**ADC Planning Consultation  
Response from the Historic Buildings Adviser**

| <b>Application Number</b> | P/76/16/PL                             |
| <b>Address</b>            | Sefter Farm, Pagham                    |
| <b>Description</b>        | Building for packaging of fresh foods. |

client			
BARFOOTS OF BOTLEY			
project			
Proposed Production Facility			
Setter Farm			
Pagham			
title			
Proposed Elevations			
date	scale @ A1	drawn	chkd
May 2016	1:200@A1	KJB	GBC
project no.	drawing no.	rev	
1603	P107	05

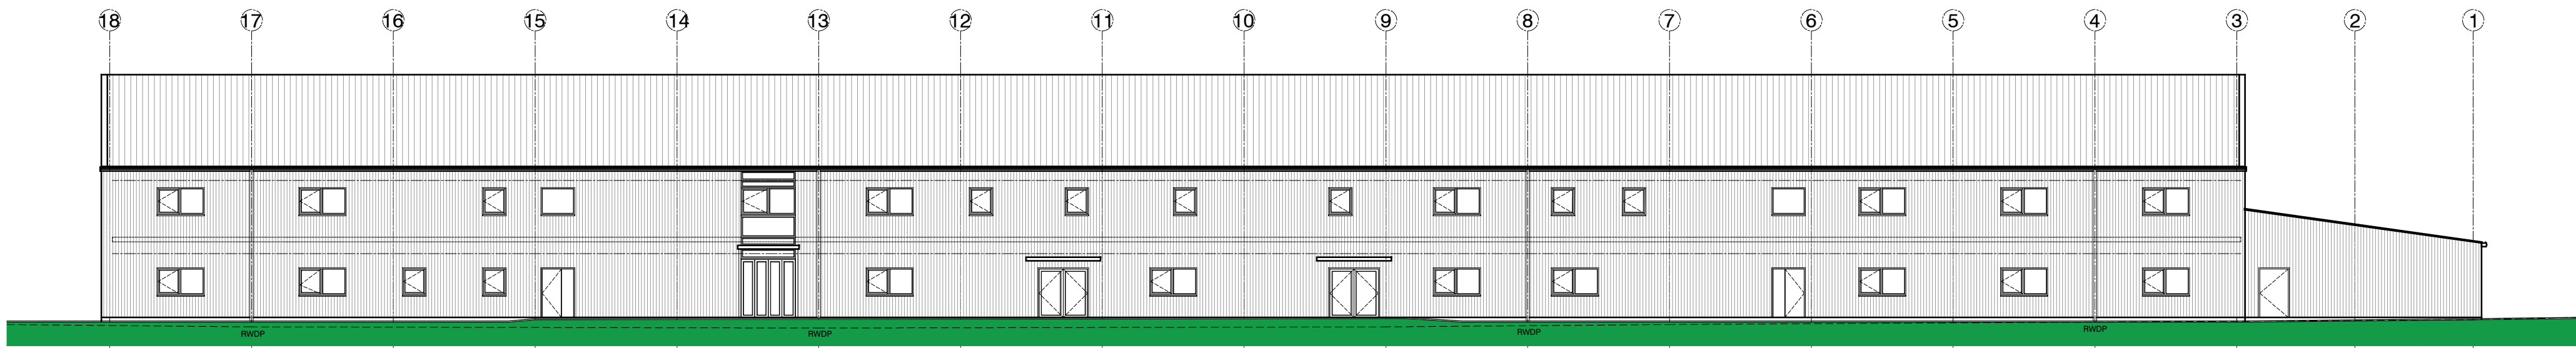
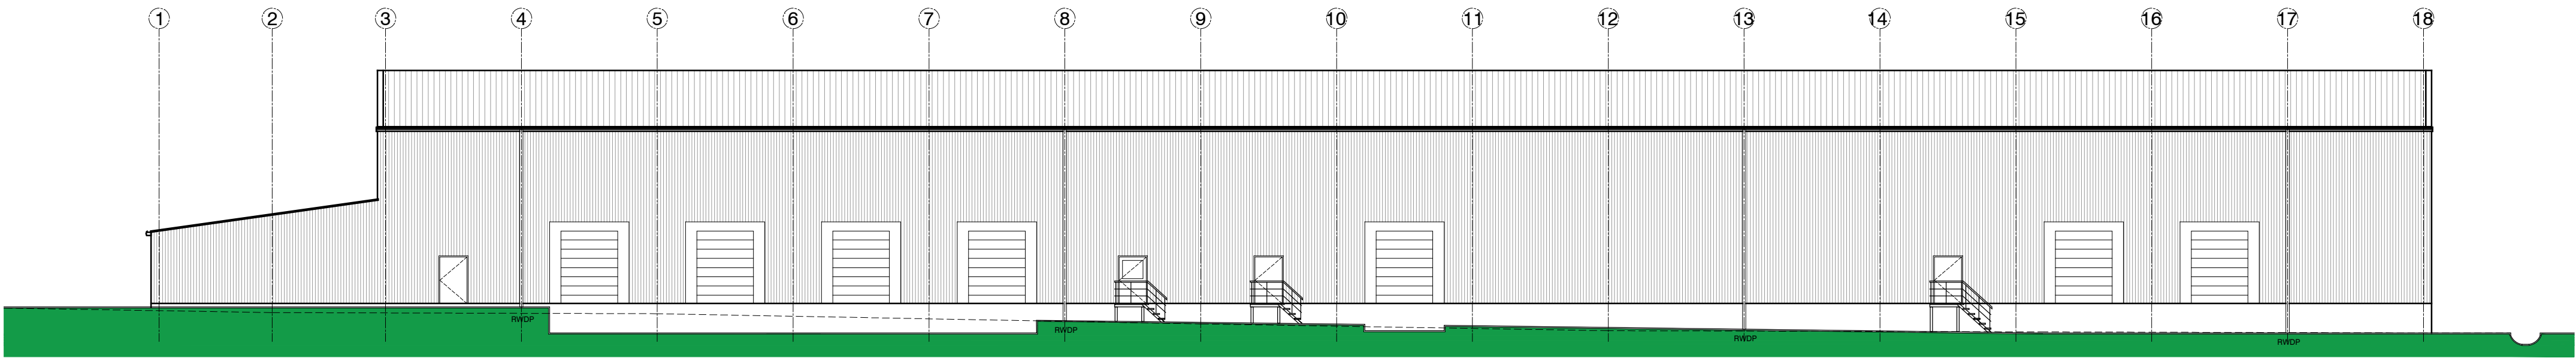
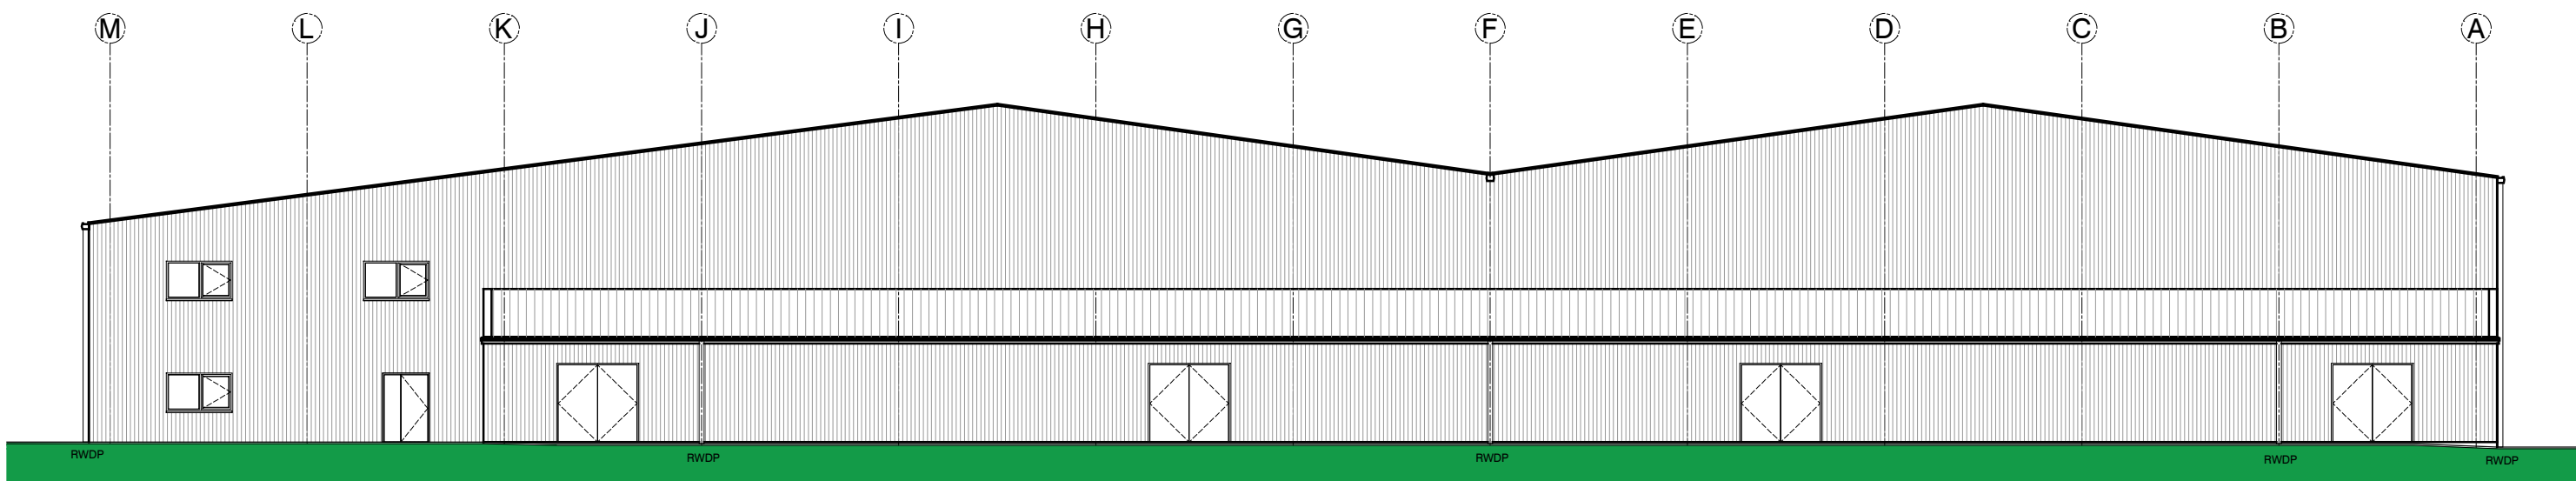
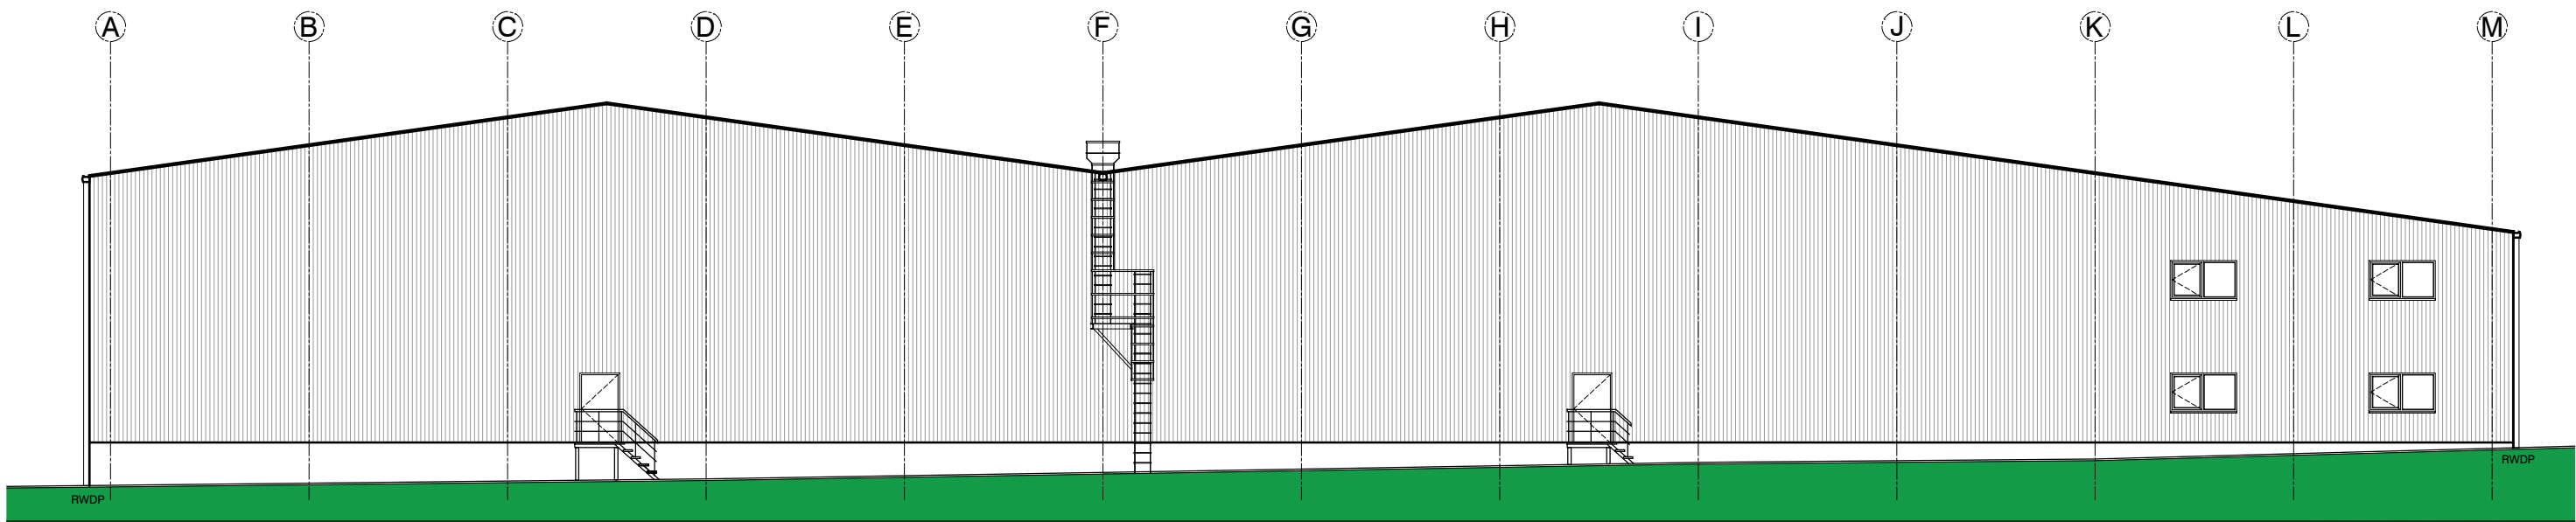
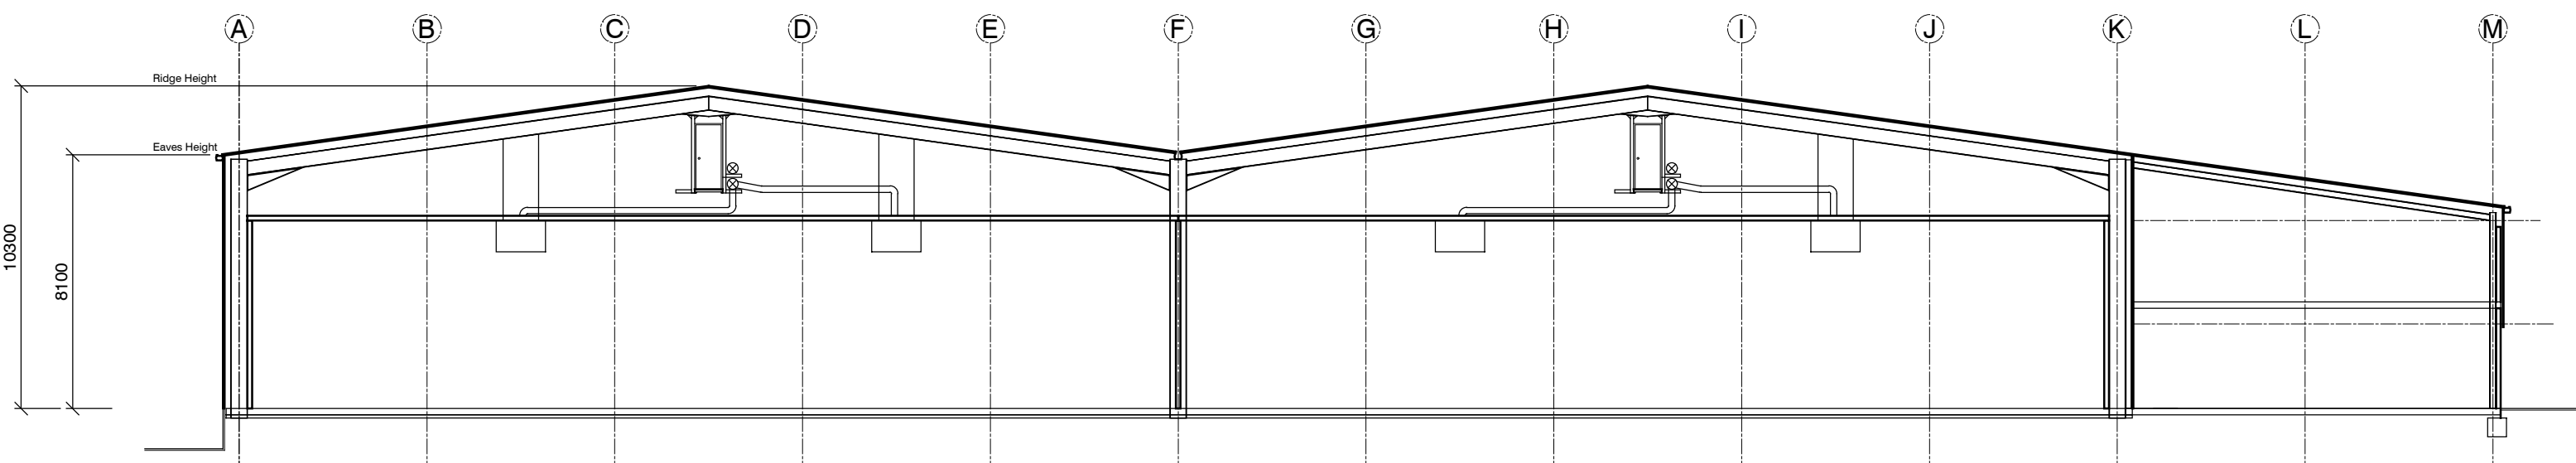
The potential impact on Rookery Farm is different, though potentially limited. The proposed building sits immediately adjacent to and south of the existing unit and is similar in appearance. It is unlikely therefore that given the distance of the view from the farm, that there will be a significant level of change in amenity. An accurate setting assessment would have helped to inform this. If there is any concern here following your site visit I would recommended that this is undertaken.
